SPR EA1N and EA2 PROJECTS

DEADLINE 9 – COMMENTS ON NATIONAL GRID SUBSTATION EXTENSION APPRAISAL

Interested Party: SASES **PINS Refs:** 20024106 & 20024110

Date: 15 April 2021 **Issue:** 1

Figure: 29.17e
Viewpoint 5: Public Right of Way, near Moor Farm

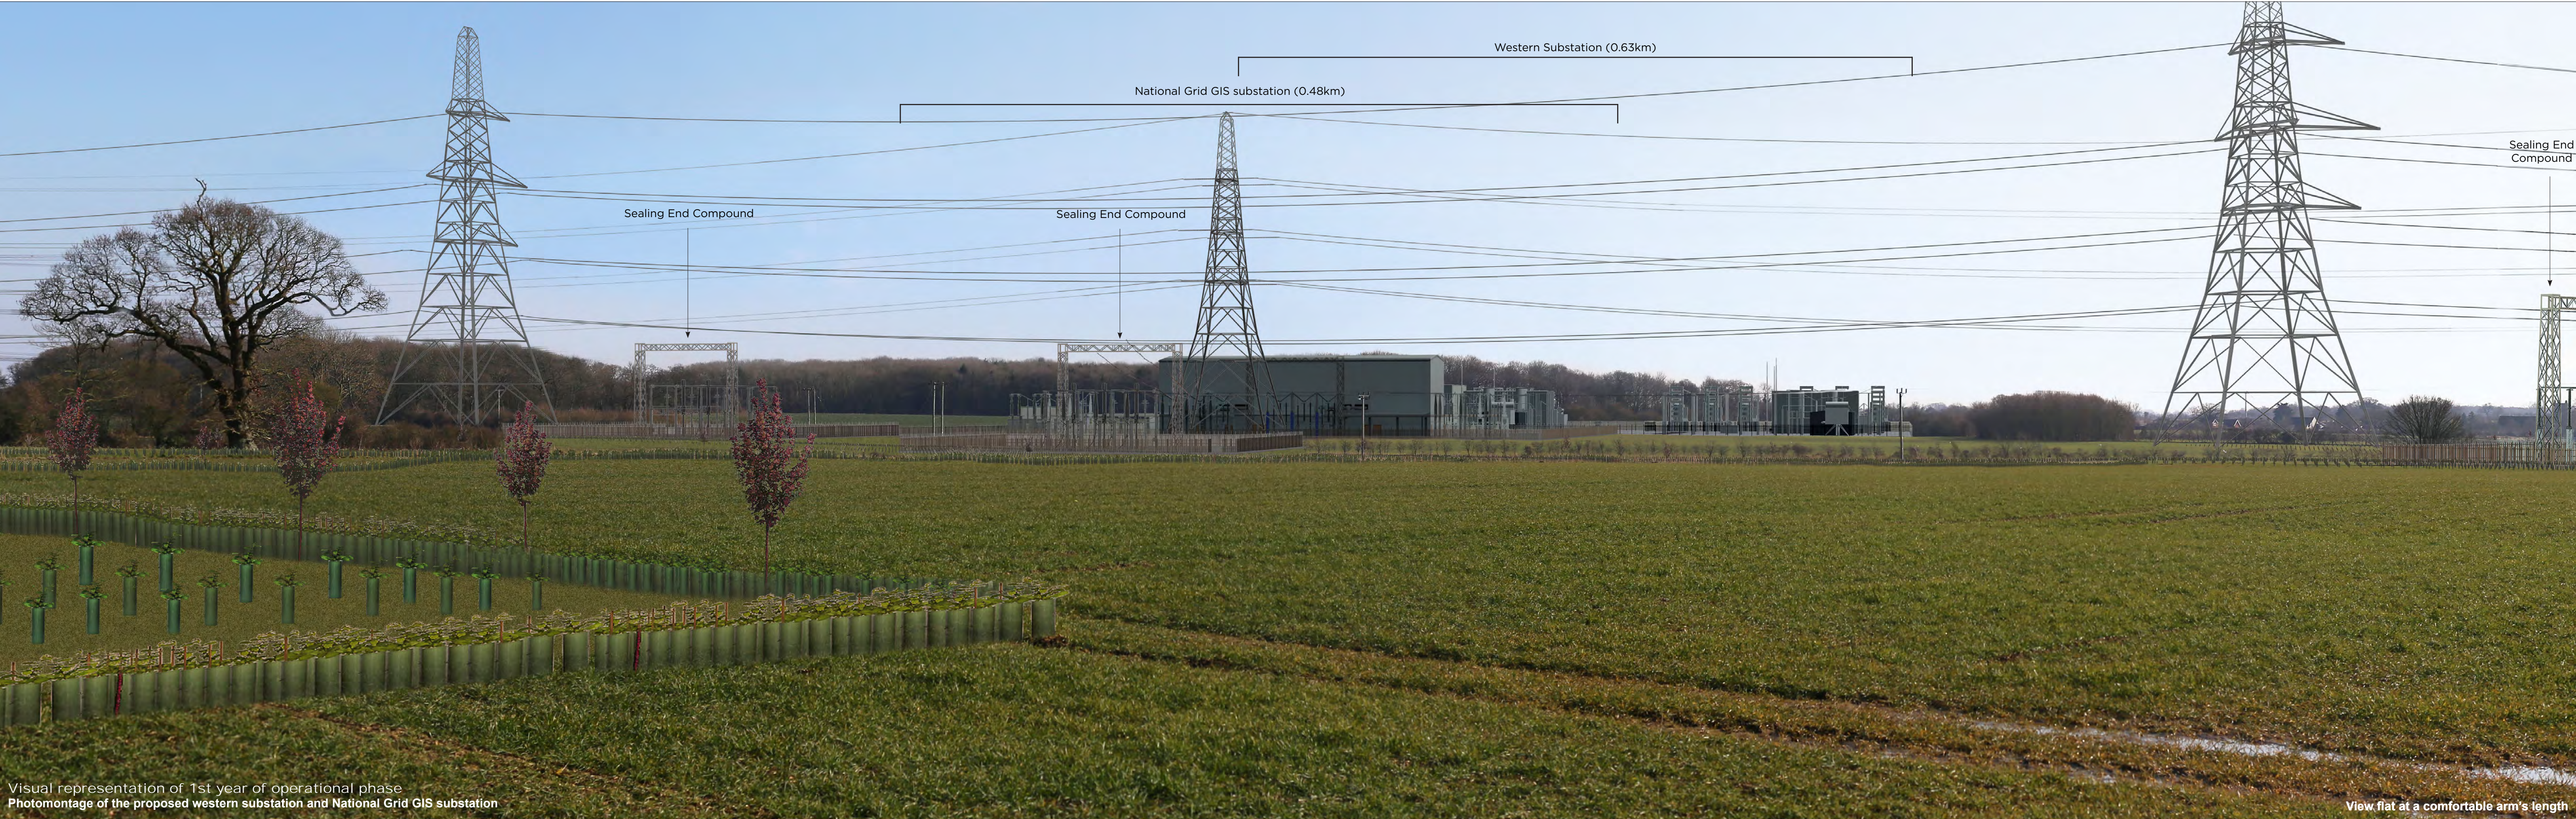
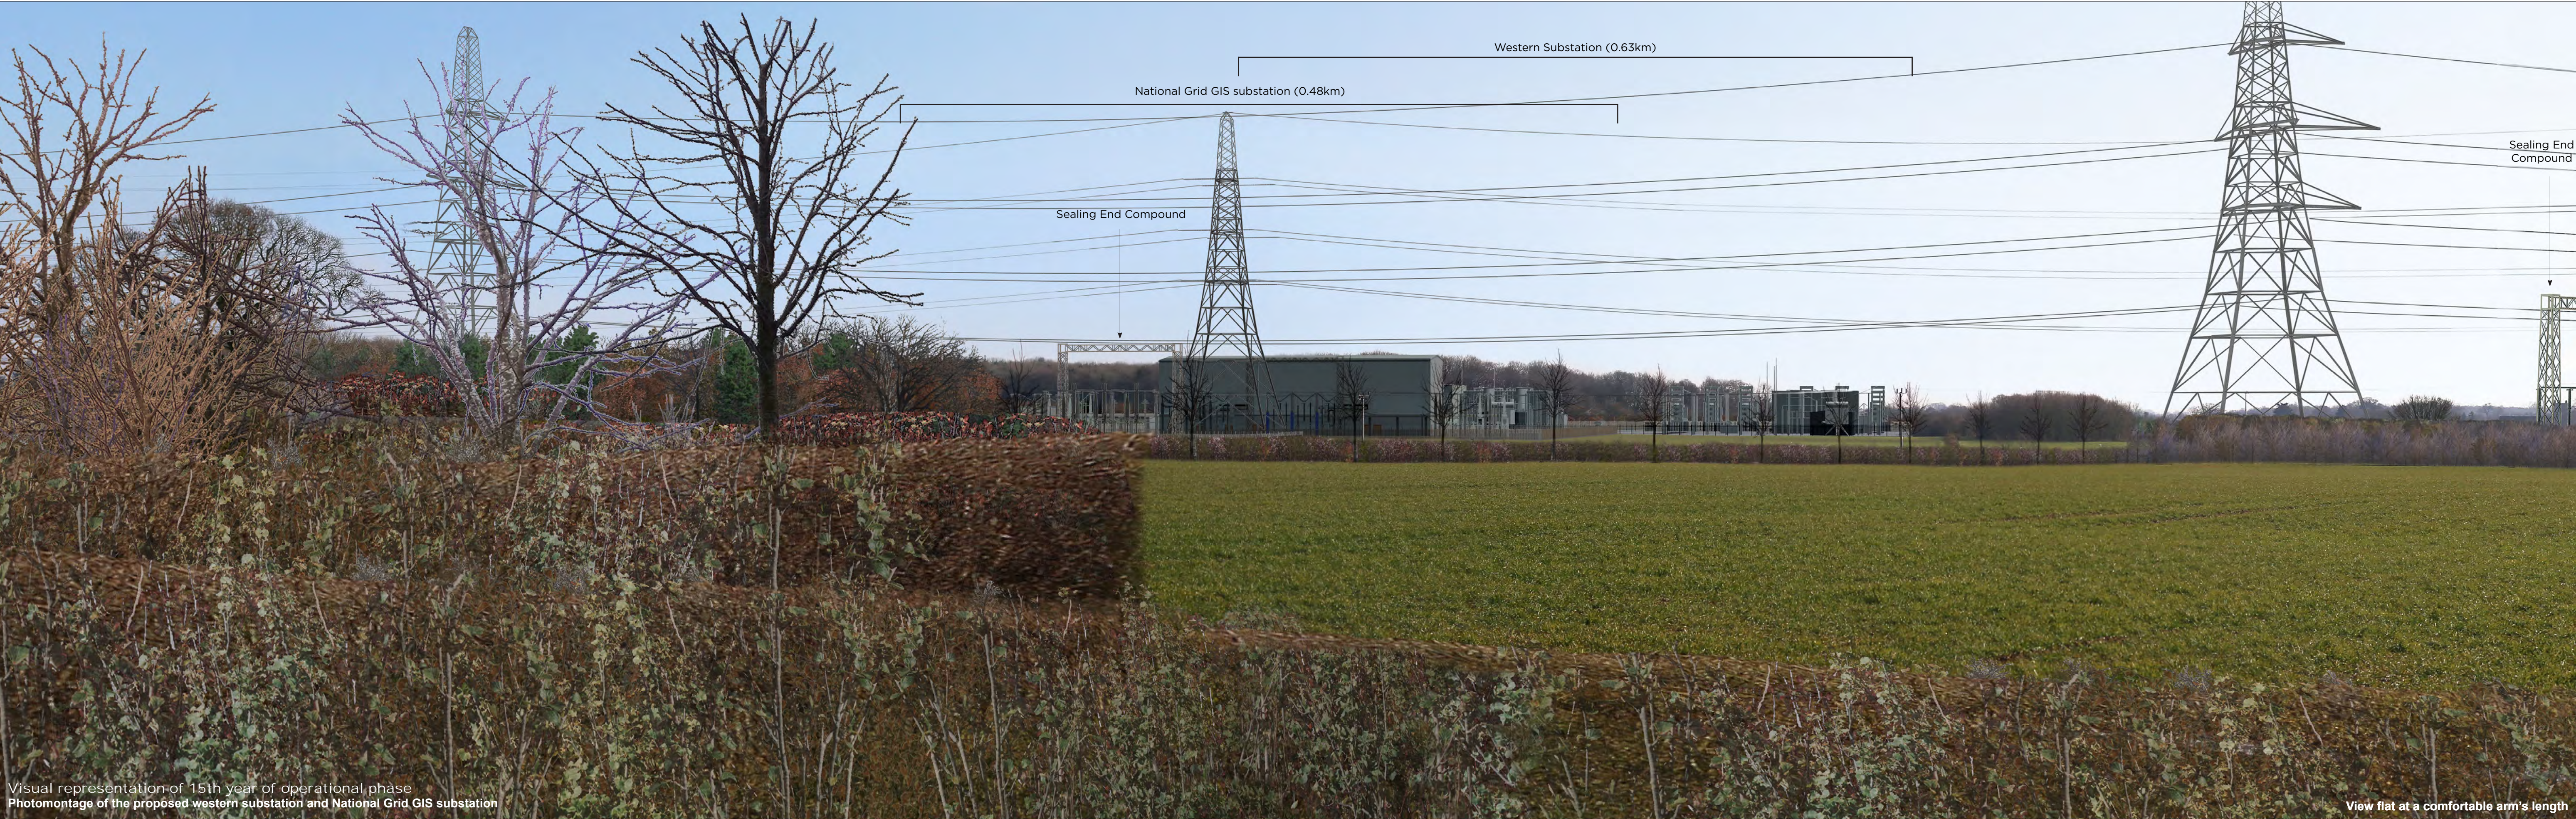
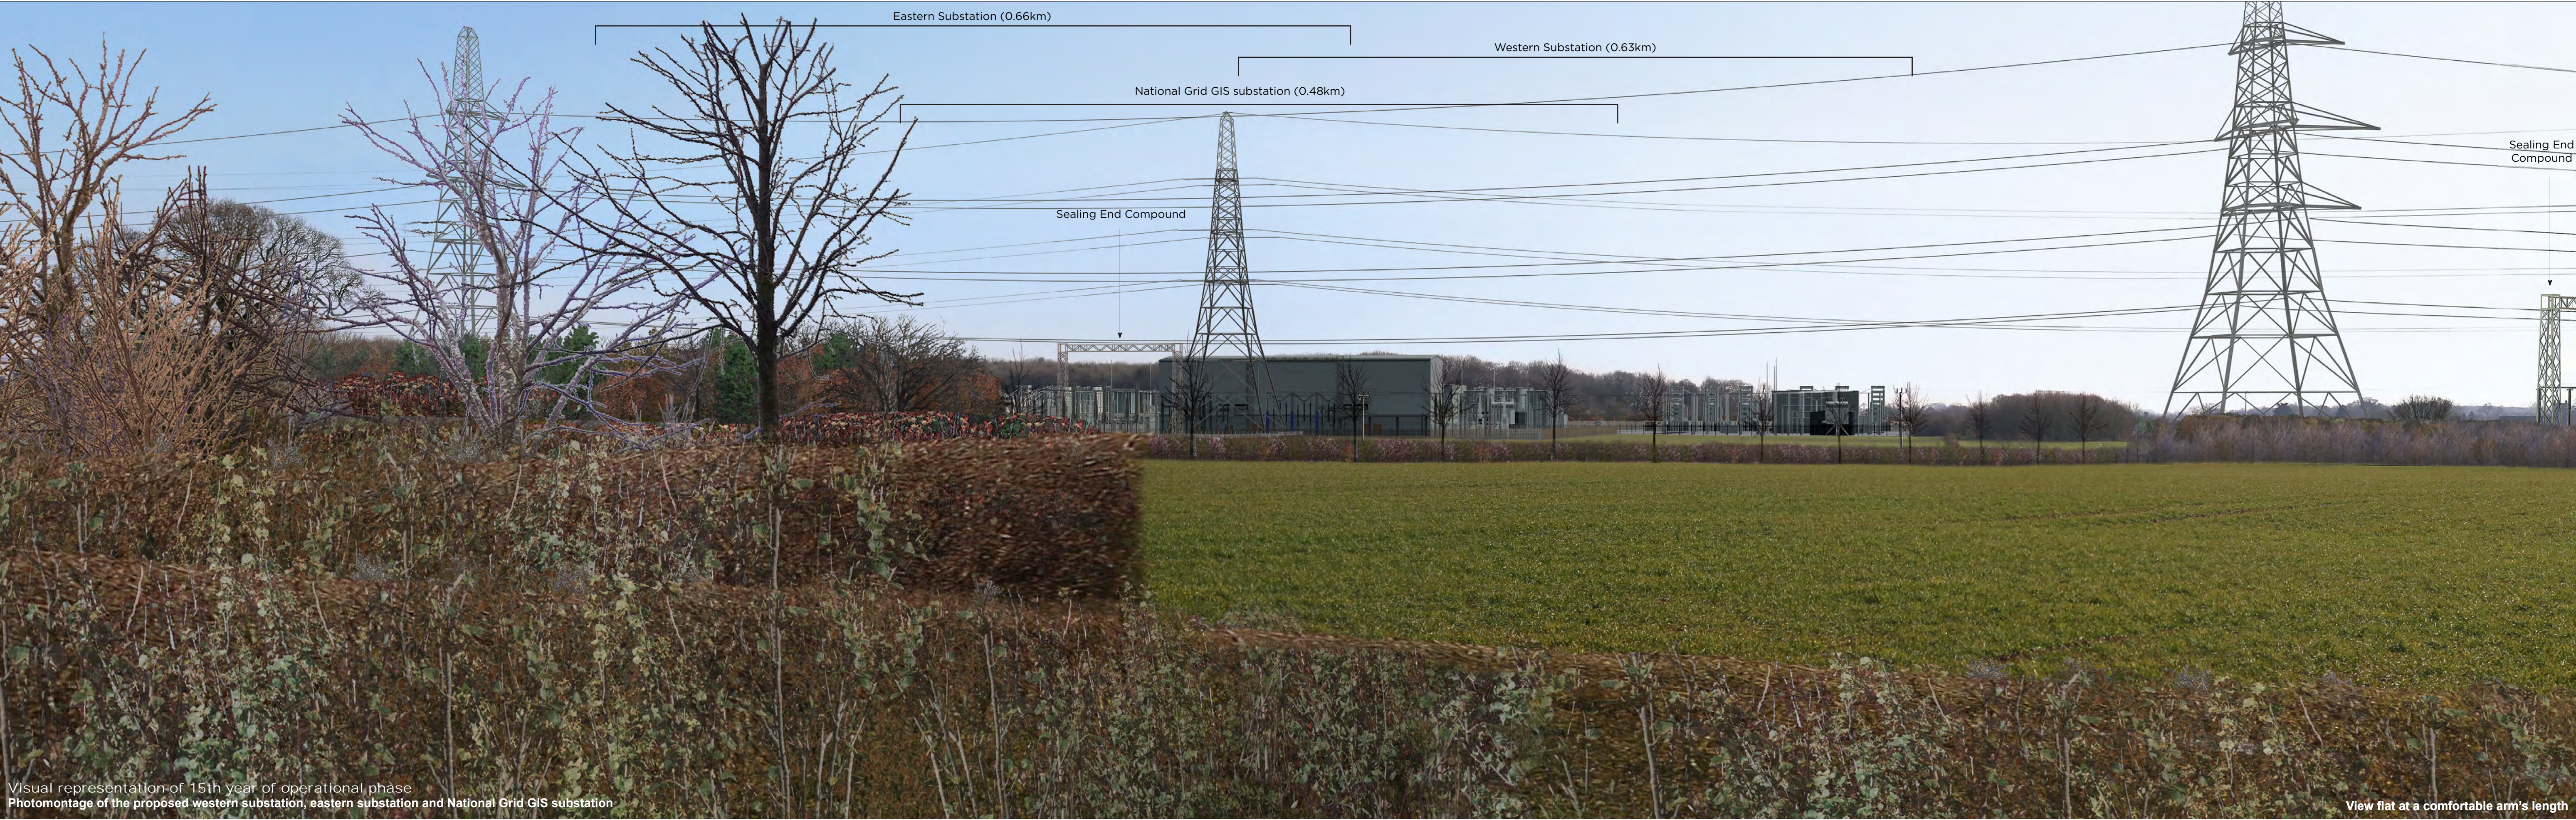
5. The Photomontage from LVIA Vp 5 shows that the western NG extension would ‘fill’ the area between the western substation and the sealing end compound, where the additional pylon is located. This would solidify the extent of the industrial landuse across the view. It would sever any possible remaining visual connection with Friston Church and the edge of Friston. Any remaining appreciation of the relationship between the village and the wider landscape would be lost.

7. Vp 5 represents the area from which there will be one of the most significant adverse impacts due to:
 - Proximity to the substations
 - The extent of development across the landscape visible a single viewpoint; and

- The restrictions on planting under the overhead lines.
8. The western NG extension would exacerbate all these factors.
 - It would be closer to Vp 5 than any of the other substations, although not closer than the sealing end compound.

- It would be visible in what is currently a 'gap' between the western substation and the sealing end compound.
 - It would be located immediately beyond a line of mitigation planting that does very little to limit views of the substations.
